Our Case Number: ACP-323849-25

Formal Observation

Re: Proposed Development — Cleeves Riverside Quarter / Cleeves Riverside Campus

ACP Reference: JA91.323849

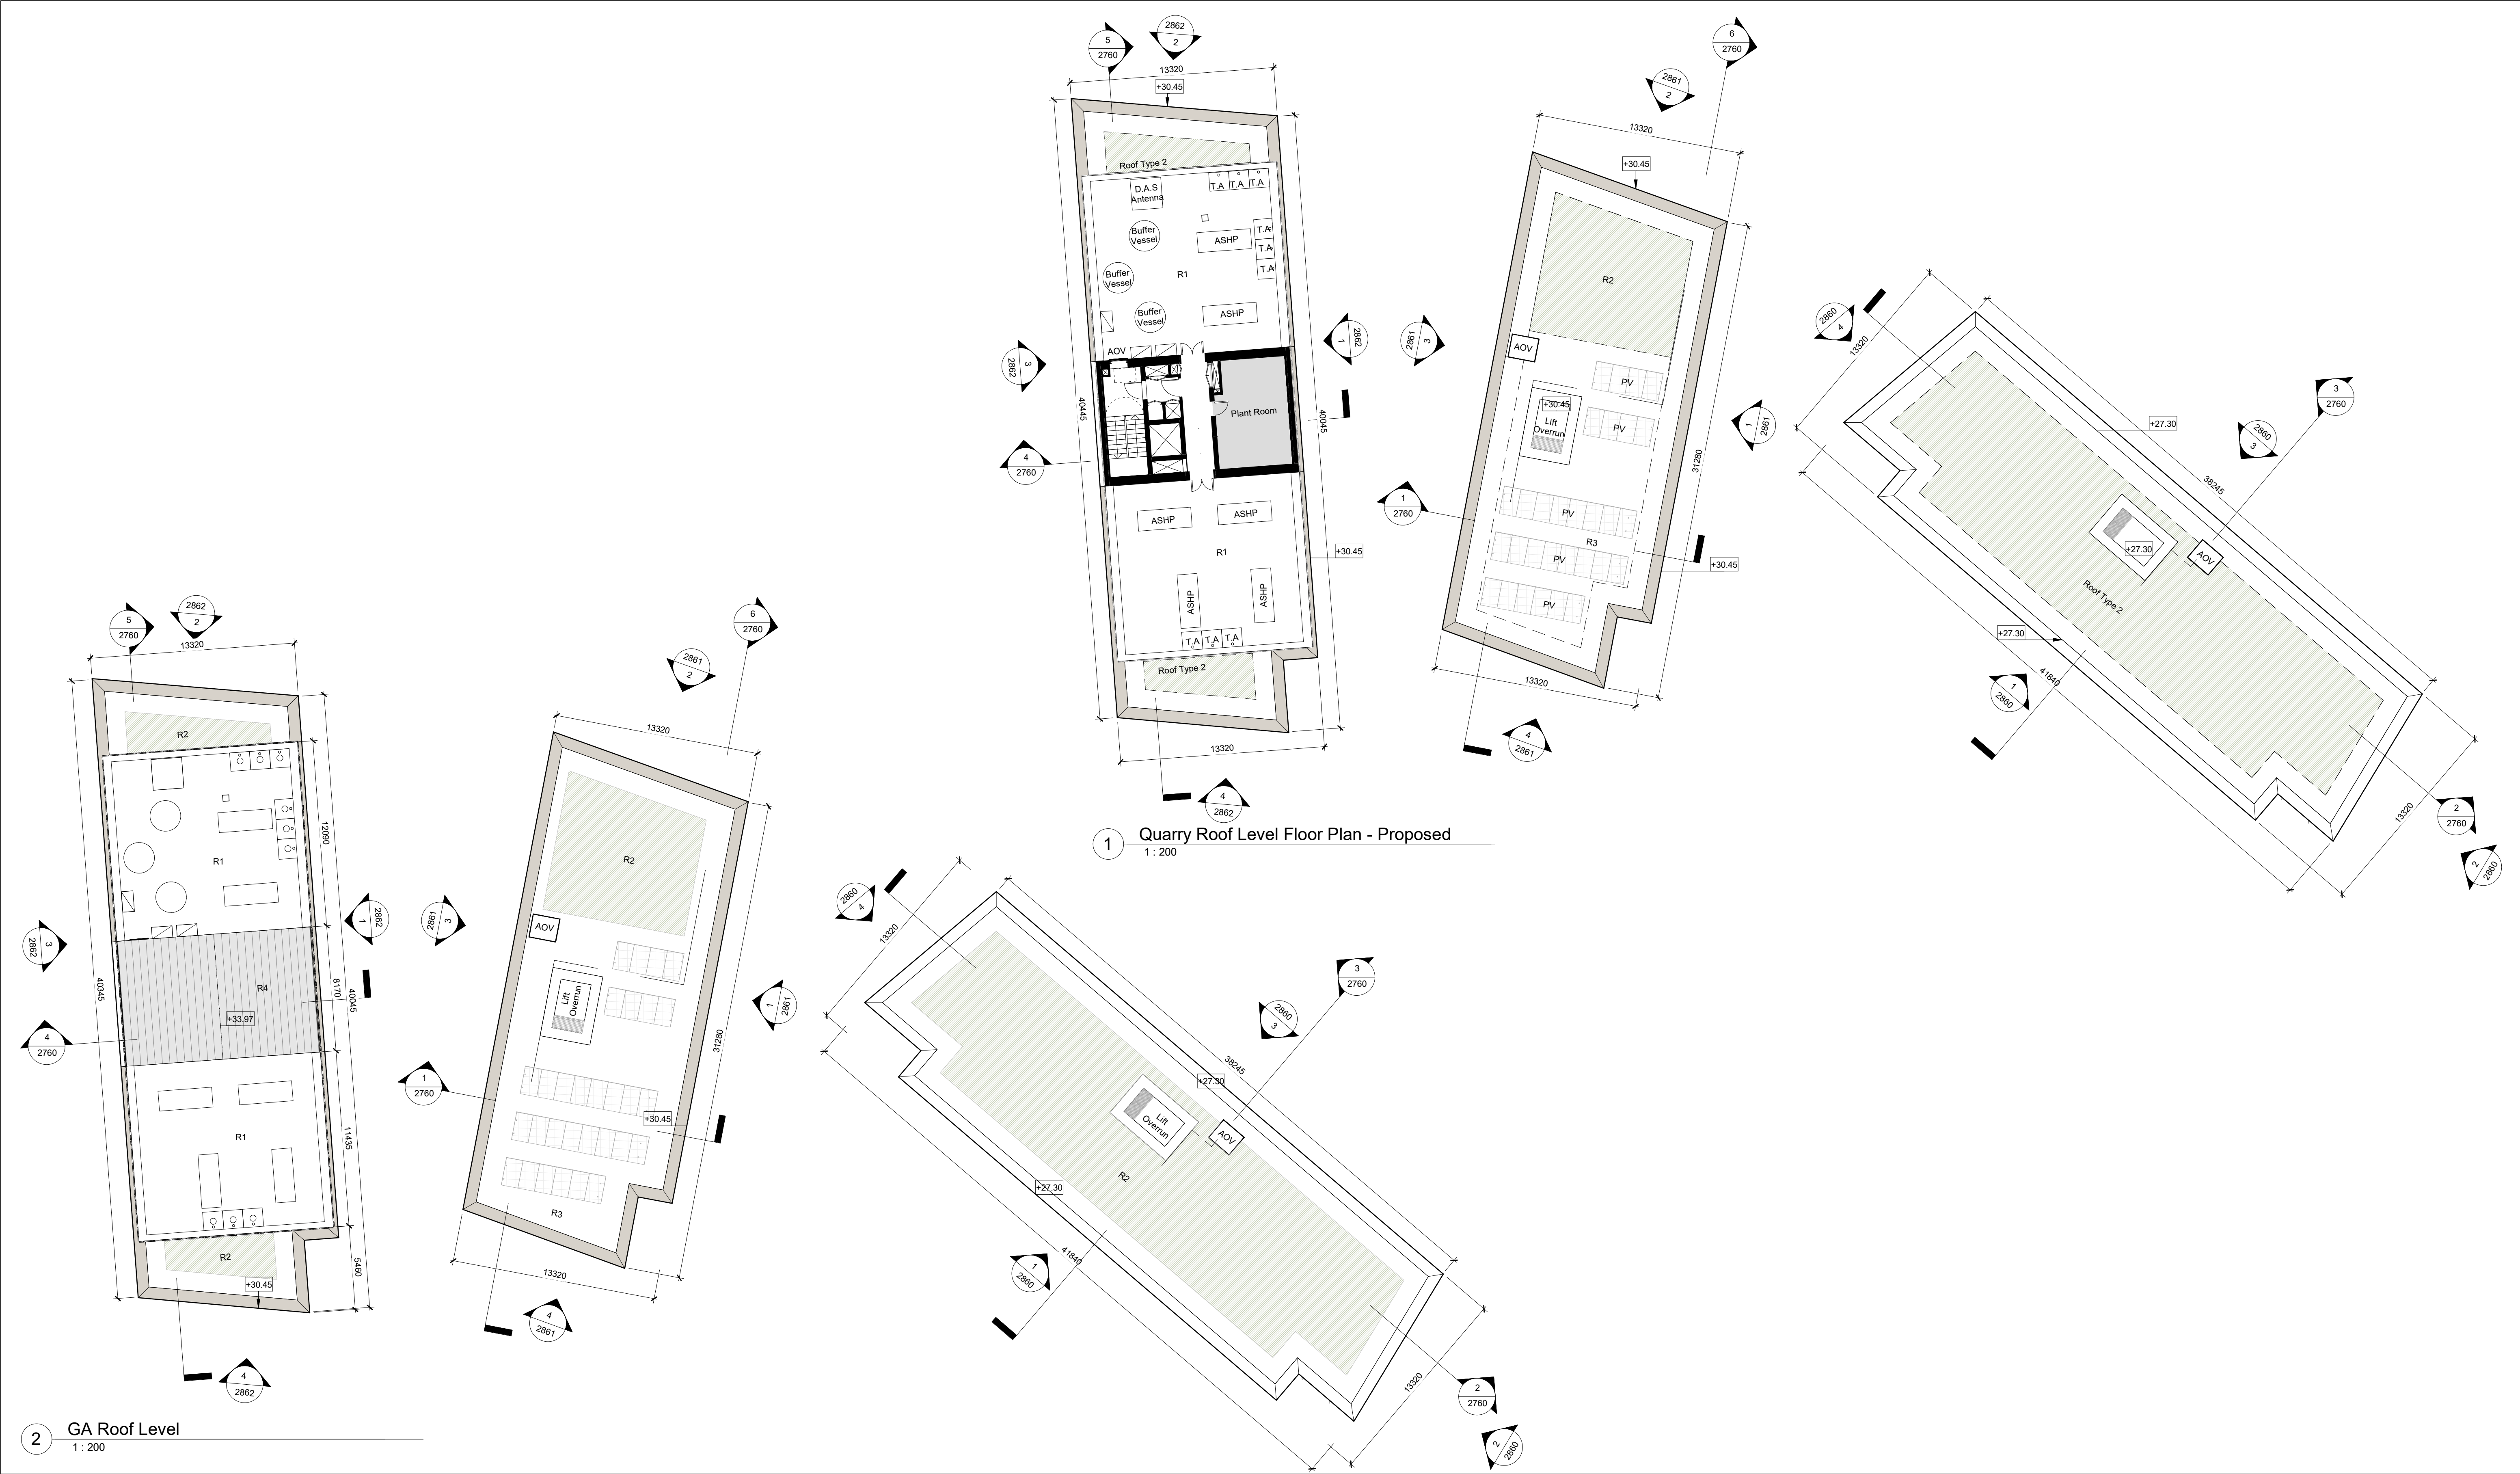
there has been no context response of the scale or design of Salesian six and seven story blocks to the two-story residential houses on Clanmaurice Avenue. A significantly more sensitive and creative approach is required, with reduced heights, stepped heights, setbacks, and varied rooflines to avoid overshadowing and visual dominance. This abrupt shift creates a stark and jarring interface between the new development and the existing community.

The proposed 5–7 storey blocks represent significant over-intensification relative to the established residential context.

All buildings within 30m of Clanmaurice Avenue should:

- Be capped at 3 storeys.
- Have higher elements significantly stepped back with varied rooflines to avoid monotony.
- Greater coherence in the design response to the sites' unique industrial heritage.
- Greater diversify of materials to blend contemporary design with industrial character.

Figure 2.8 Buildings Proposed for Demolition highlighted in red with buildings to be retained identified in grey.

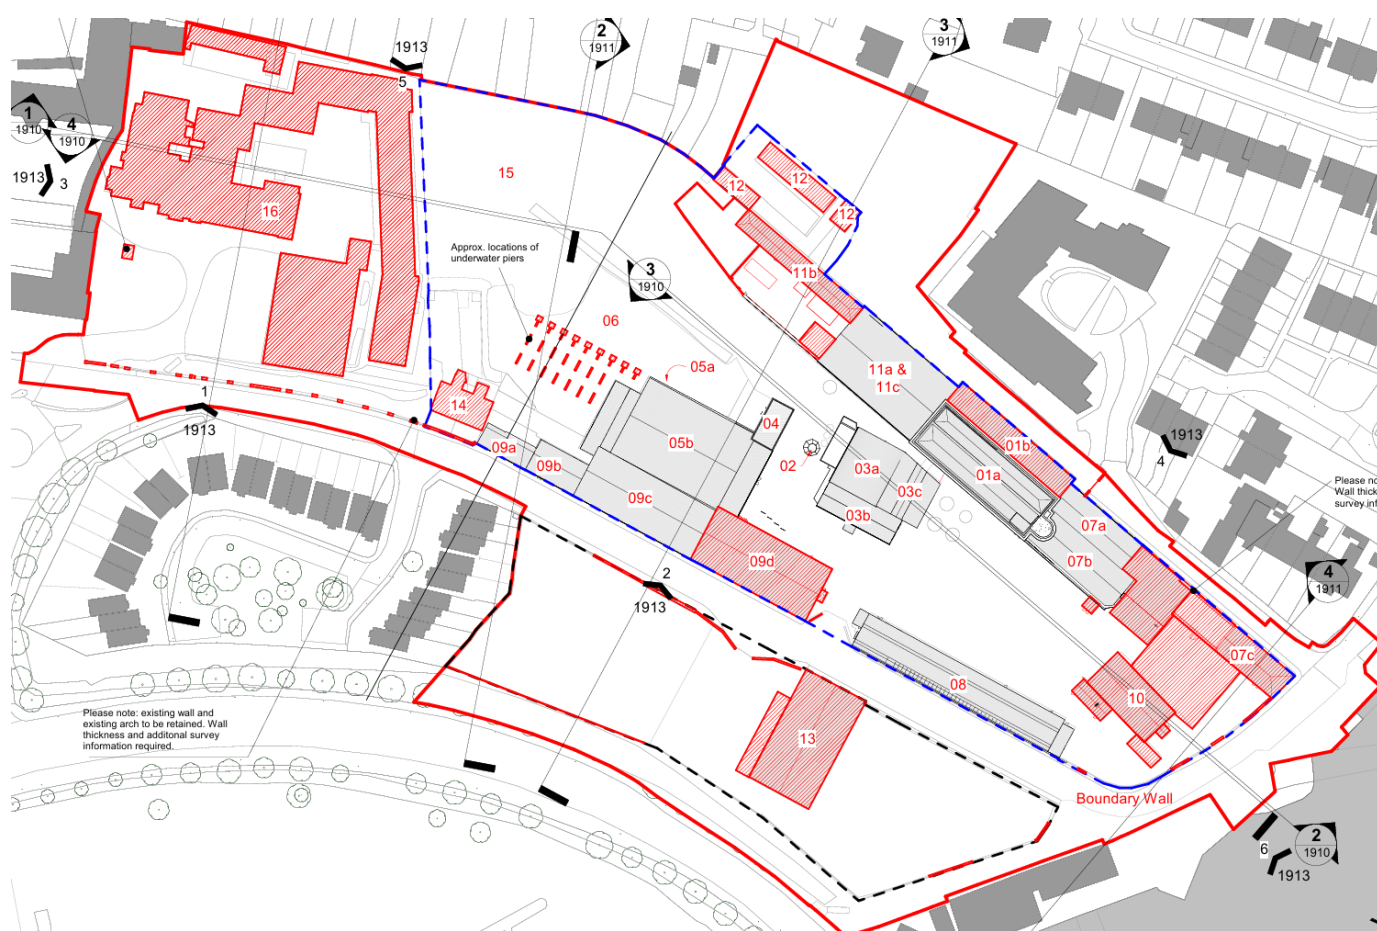
The development will cause material harm to the heritage assets in the vicinity, specifically: Fernbank House, the original home of the Cleeves Family. Limerick Twenty Thirty's own heritage documentation acknowledges that Fernbank is: "One of the early original homes on NCR" and that its importance "may be greater once researched." Yet, it is proposed to demolish the house as part of the greater Cleeve's site. Photos below (Fig 2.) show the almost perfect interior of the inside of this culturally rich and significant building. It was built c.1860, not in the 20th century as stated by Limerick 2030. This building was in use daily until 2020 when the local authority purchased the entire site. It was last visited and photographed in 2020 and was in a dry, manageable and fit state. There is absolutely no reason why this house should be demolished, especially during a housing crisis and climate emergency.

- **Harm to the setting of a building that should be listed as a protected structure:** The proposed development requires the destruction of Fernbank House, which is an architectural gem.
- It will be visible from and in close proximity to the NCR and will result in the loss of a key part of our architectural history and heritage in Limerick's North side.
- Fernbank House, a part of the Salesians Secondary school site, not mentioned in the plans of the local authority, is an important local heritage asset. The scale, design, and materials of the proposed development are fundamentally out of character with the historical setting of the building and will result in a significant and irreversible loss of its special architectural and historic interest. The loss of a key historical view from the building and its grounds is a serious concern.

- **In the application no mention of this building is made.** It is to be demolished as per the plans. However this was one of the first buildings on the north side of the river bank at Limerick from 1800- onwards.

- Local Authority to list this building as a protected structure in alignment with local and national guidelines and as has been called for by locals and local historians alike for years, since its purchase.
- Provide a Conservation Report and structural appraisal
- Provide a Structural appraisal and reuse proposal
- Provide adaptive reuse proposal
- Design to respond to and meaningfully integrate Fernbank house into the proposed masterplan

Figure 2.9 Proposed Haulage Route for Materials in Red Line

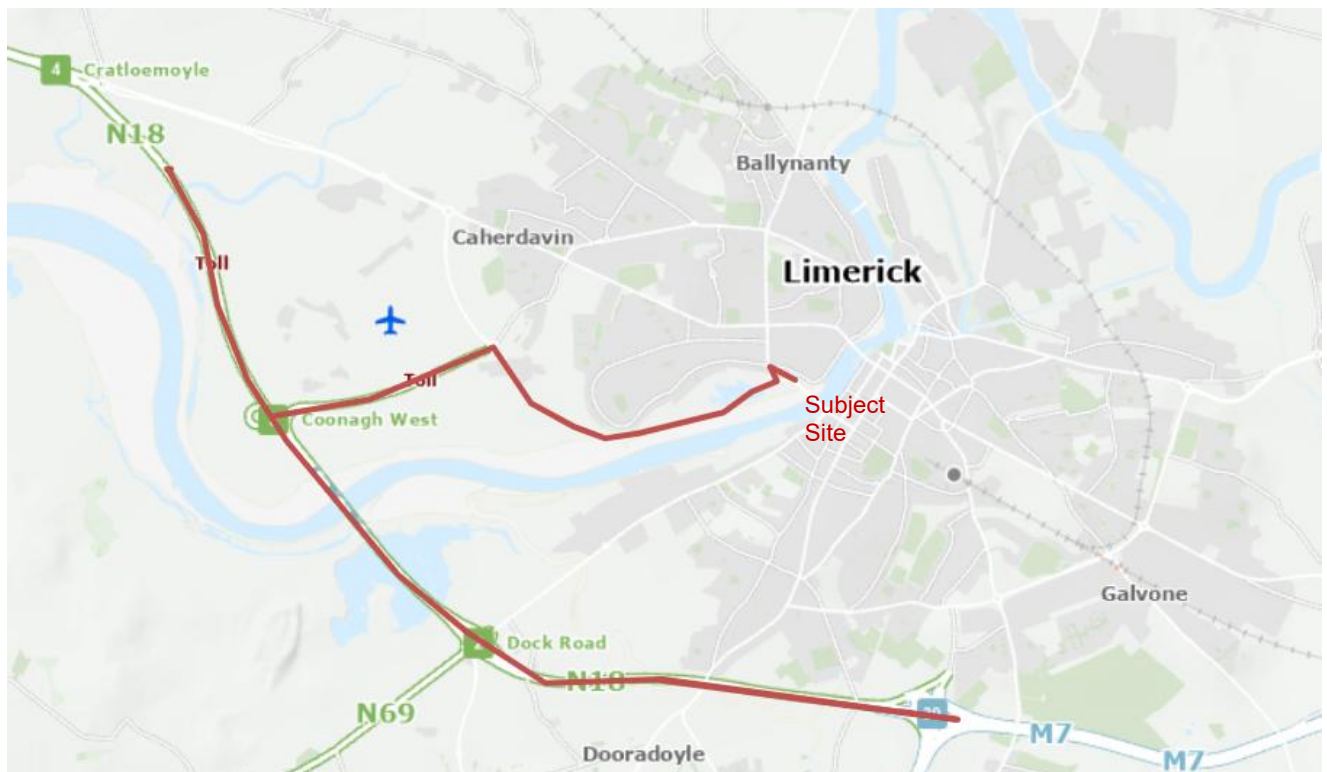
- No completed and binding Construction Traffic Management Plan (CTMP) is provided
- no HGV routing strategy is shown;
- no pedestrian/cyclist diversions are proposed;
- no timing or peak-time limitations are identified;

- no haul routes or turning arrangements are included.

1. Full updated TTA
2. Stage 1/2 RSA
3. CTMP at application stage
4. Binding prohibition on construction/operational access via Clanmaurice Avenue
5. DMURS-compliant pedestrian/cyclist mitigation
6. Revised mobility strategy based on existing conditions
